East Pye Solar
Applicant's Response to Advice and Observations at
Acceptance

Planning Inspectorate Reference: EN0110014

Document Reference: APP/8.1

Planning Act 2008: Application for a Development Consent Order for East Pye Solar - Response to Section 51 Advice

Sources: Esri, TomTom, Garmin, FAO, NOAA, USGS, © OpenStreetMap contributors, and the GIS User Community

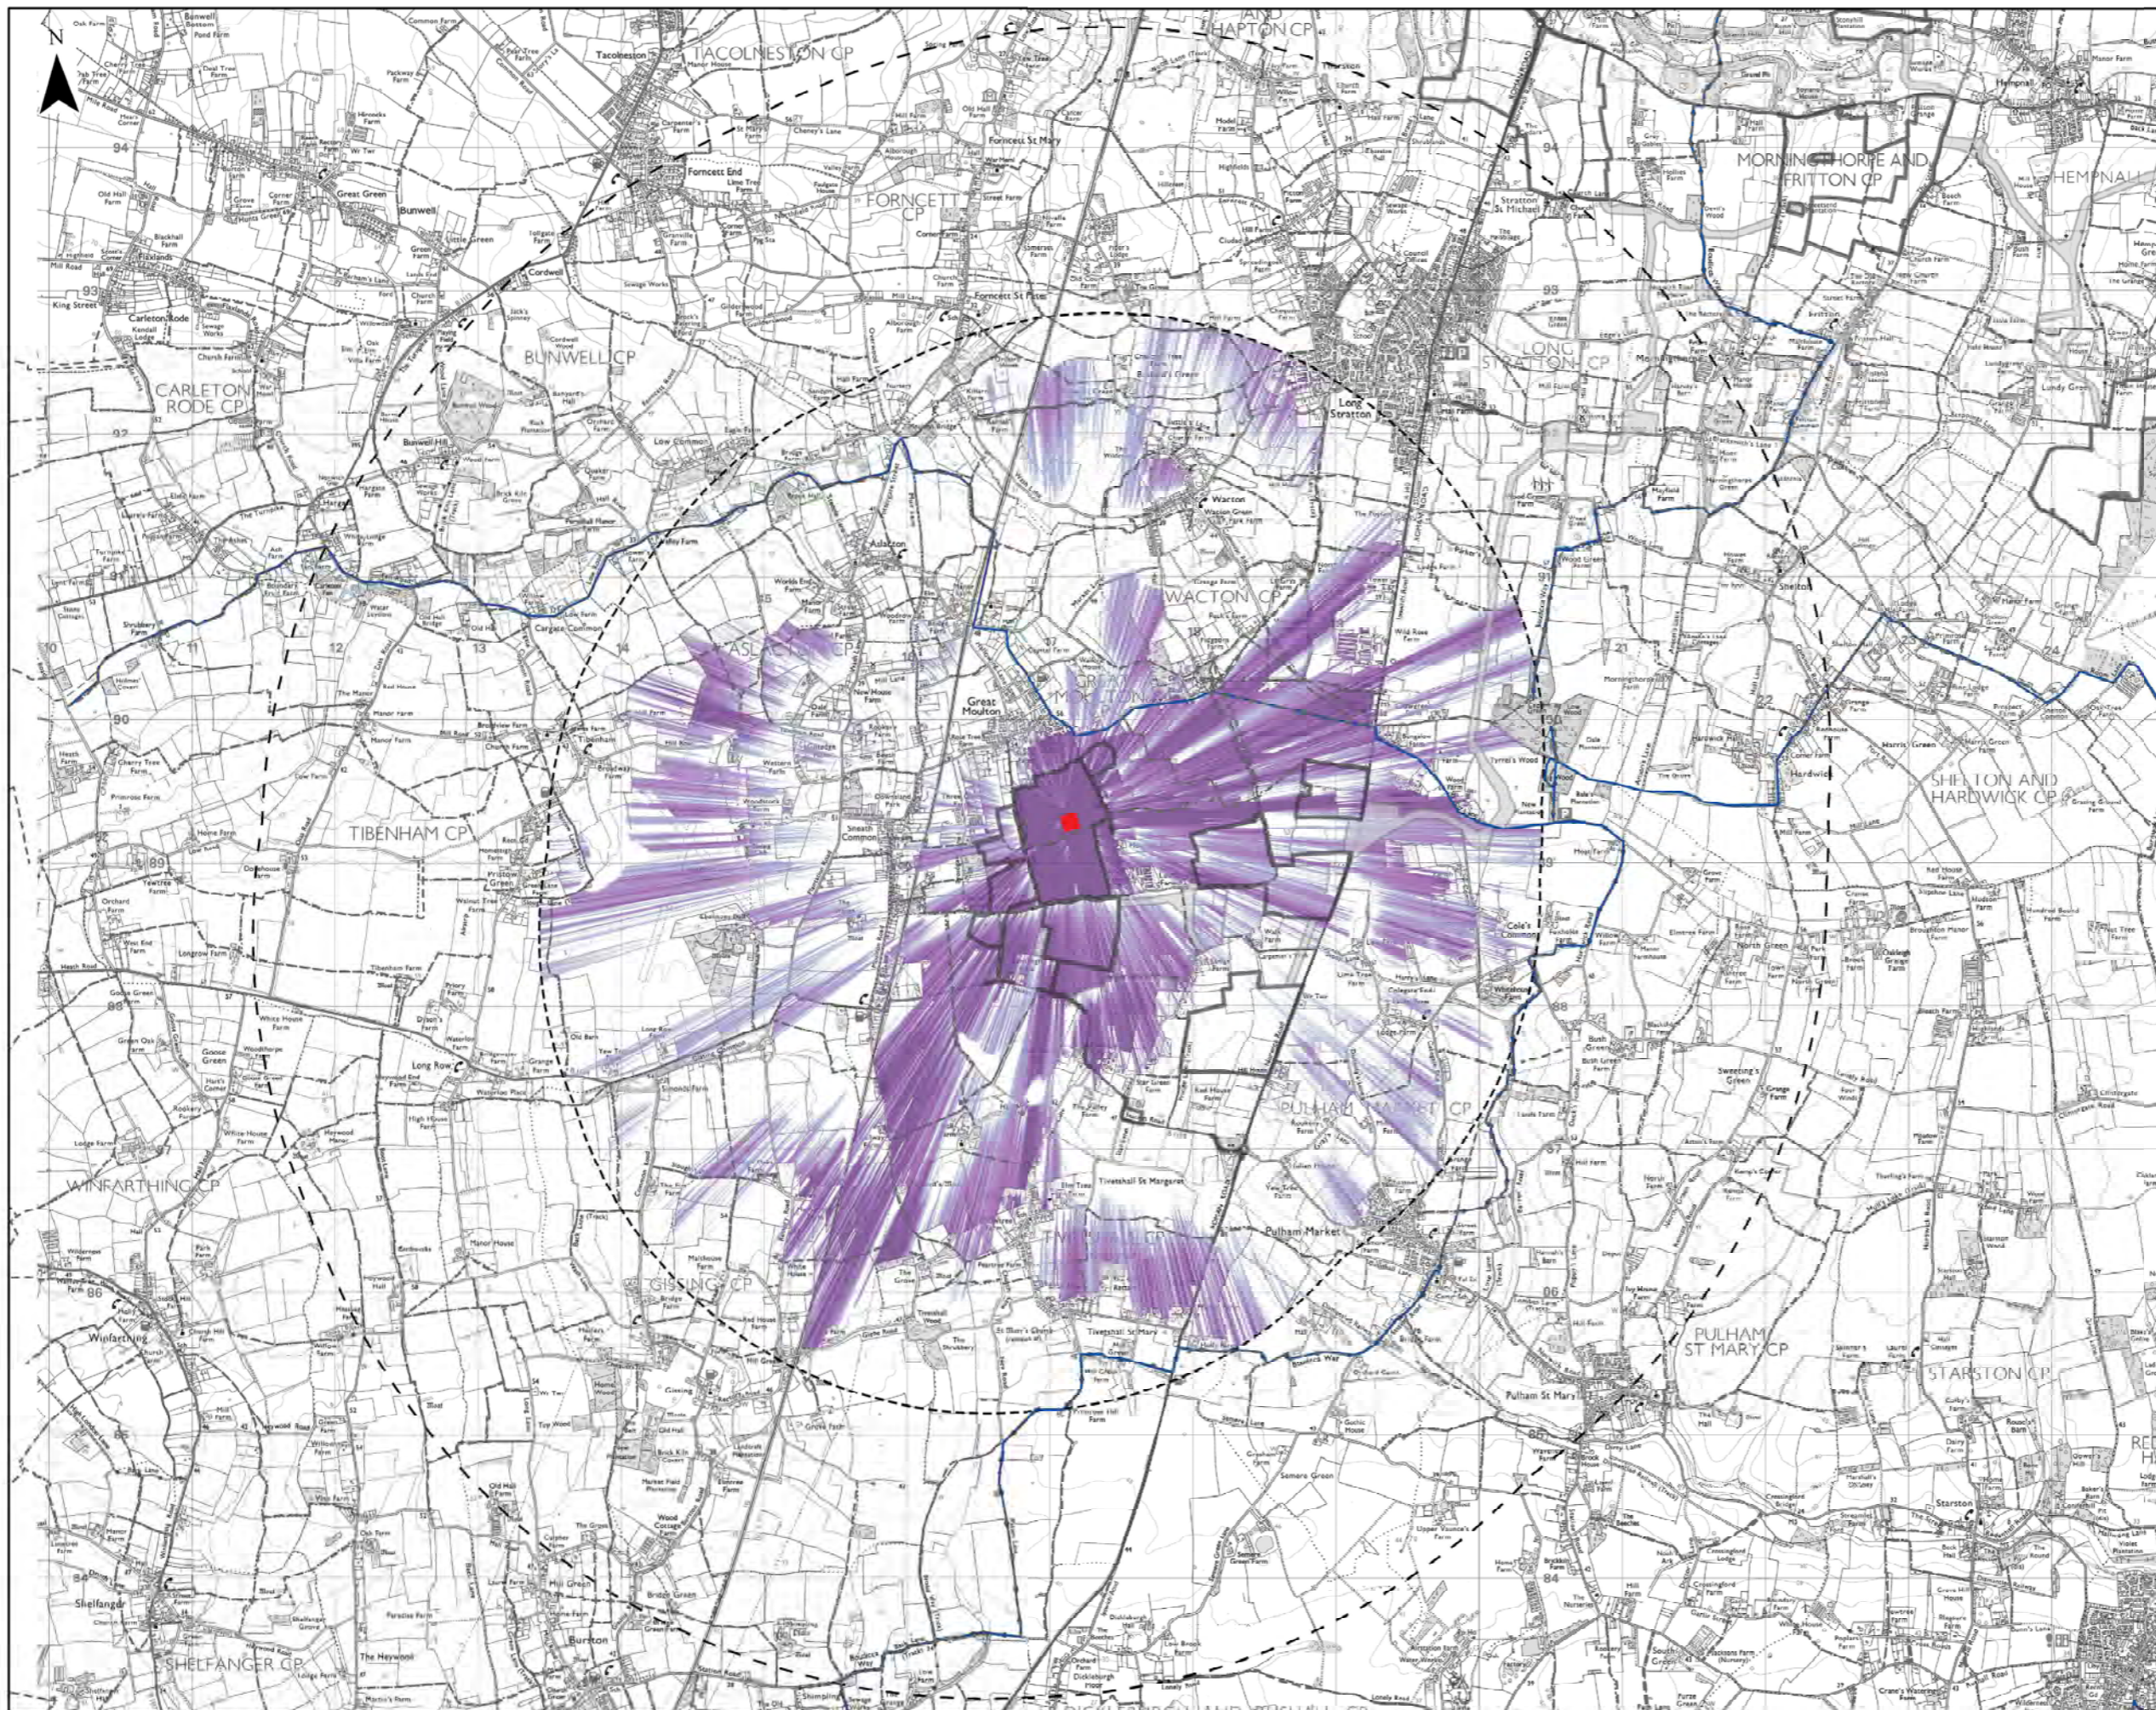
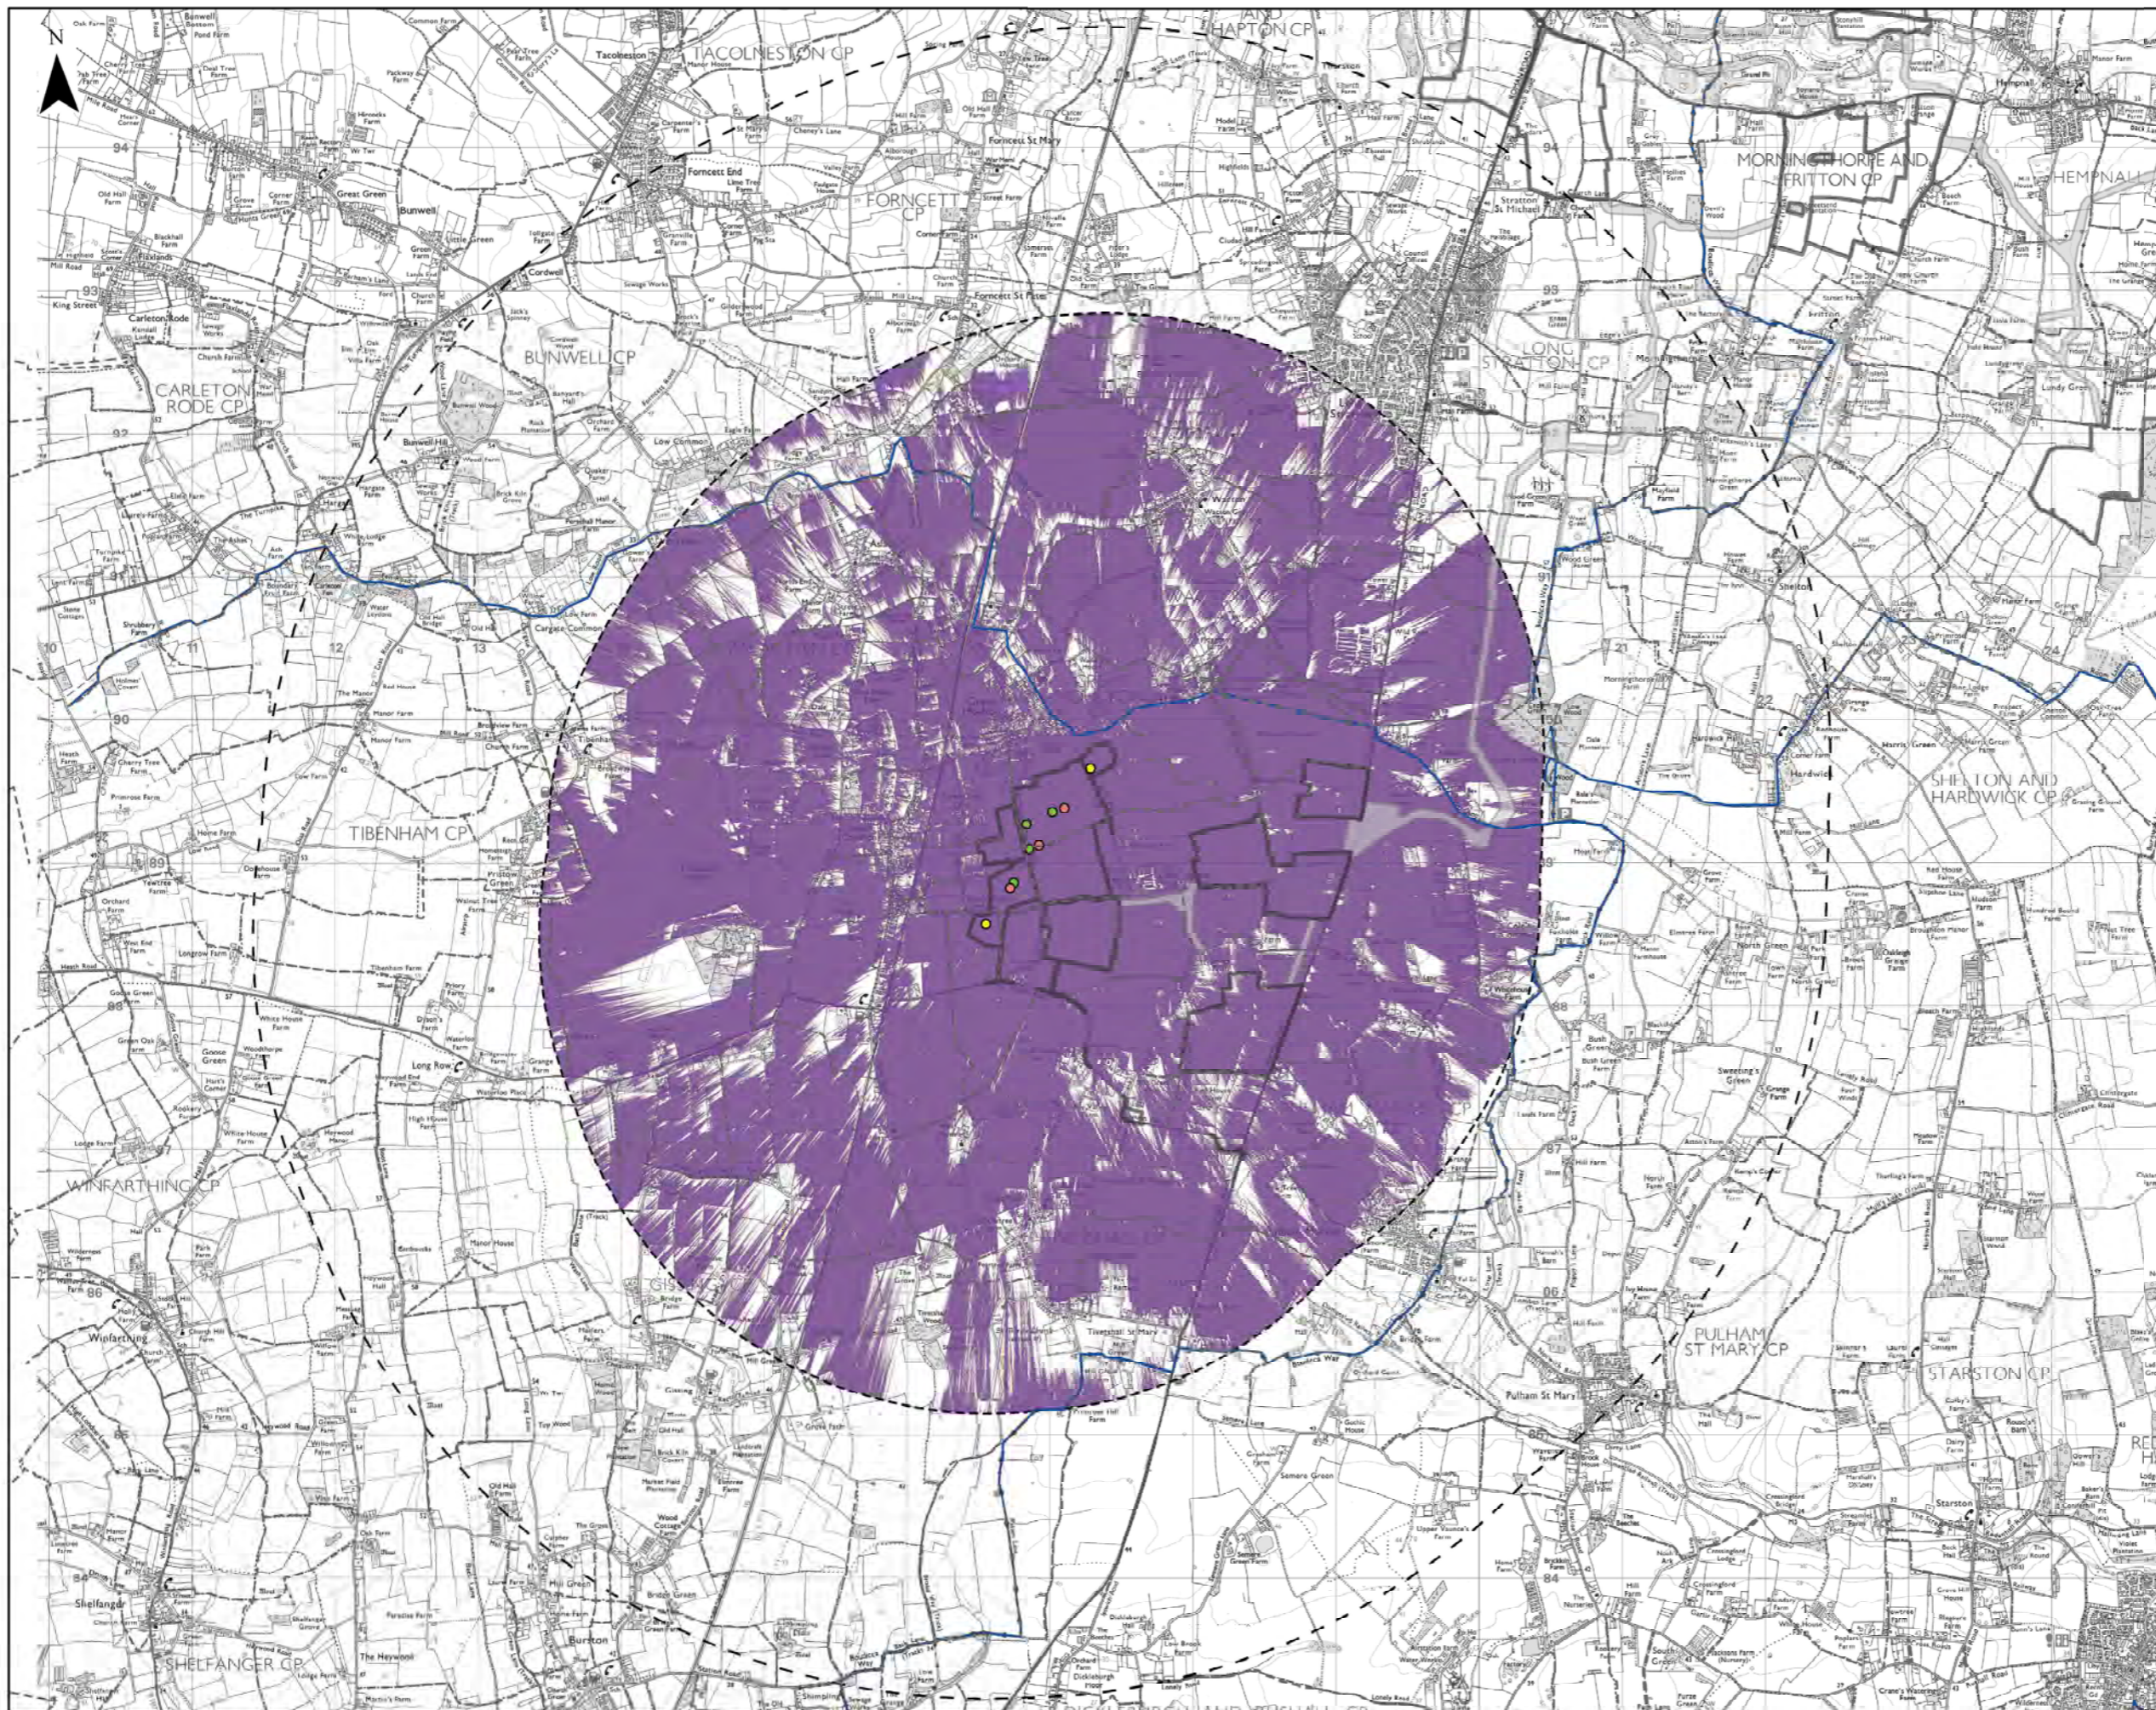
Plans and Figures The applicant is asked to submit revised Volume 2 and 6 documents that eliminate rendering issues and allow multiple files to be opened concurrently. This applies to several figures (such as documents 6.2.5.4, 6.2.7.5 (10), 6.2.7.6, 6.2.7.7, and 6.2.15.1), which range in size from 42.5 MB to 90.8 MB, plan document numbers 2.3 (69 MB) and 2.12 (78.1 MB), as well as to appendices attached to Environmental Statement chapters, such as document 06.03.18.01, which is 145.9 MB.	Reduced file size versions of the following DCO Application documents were provided to the Planning Inspectorate with the Applicant's initial response to the Section 51 advice [AS-001]. Where reducing the size of documents was not feasible, the document has been split into Parts. ■ Works Plan. Part 1 and Part 2 [AS-002 and AS-003]. ■ Hedgerow and Tree Protection Order Plan [AS-004].

Planning Inspectorate Comments	Applicant's Response
	■ Environmental Statement Volume 2: Figure 5.4 – Alterations to the Site Boundary between the PEIR and Submission [AS-006]. ■ Environmental Statement Volume 2: Figure 7.5.10 – Site 1 Zone of Theoretical Visibility [AS-007]. ■ Environmental Statement Volume 2: Figure 7.6 – Visual Receptors Plan [AS-008]. ■ Environmental Statement Volume 2: Figure 7.7 – View Locations and Visualisations [AS-009]. ■ Environmental Statement Volume 2: Figure 15.1 - ALC Results [AS-010]. ■ Environmental Statement Volume 3 Appendix 7.5 Photosheets – Cable Route Corridor. Part 1 and Part 2 [AS-011 and AS-012]. ■ Environmental Statement Volume 3 Appendix 7.5 Photosheets – Site 7. Part 1 and Part 2 [AS-013 and AS-014]. ■ Environmental Statement Volume 3 Appendix 7.6 Figure 7.6.7 Visualisations – Site 7. Part 1 and Part 2 [AS-015 and AS-016]. ■ Environmental Statement Volume 3: Appendix 8.1– Ecological Desk Study and Extended Habitat Survey [AS-017]. ■ Environmental Statement Volume 3: Appendix 9.1– Flood Risk Assessment & Outline Surface Water Drainage Strategy [AS-018 and AS-019]. ■ Environmental Statement Volume 3: Appendix 10.2 – Archaeological Desk-Based Assessment. Part 1 and Part 2 [AS-020 and AS-021].
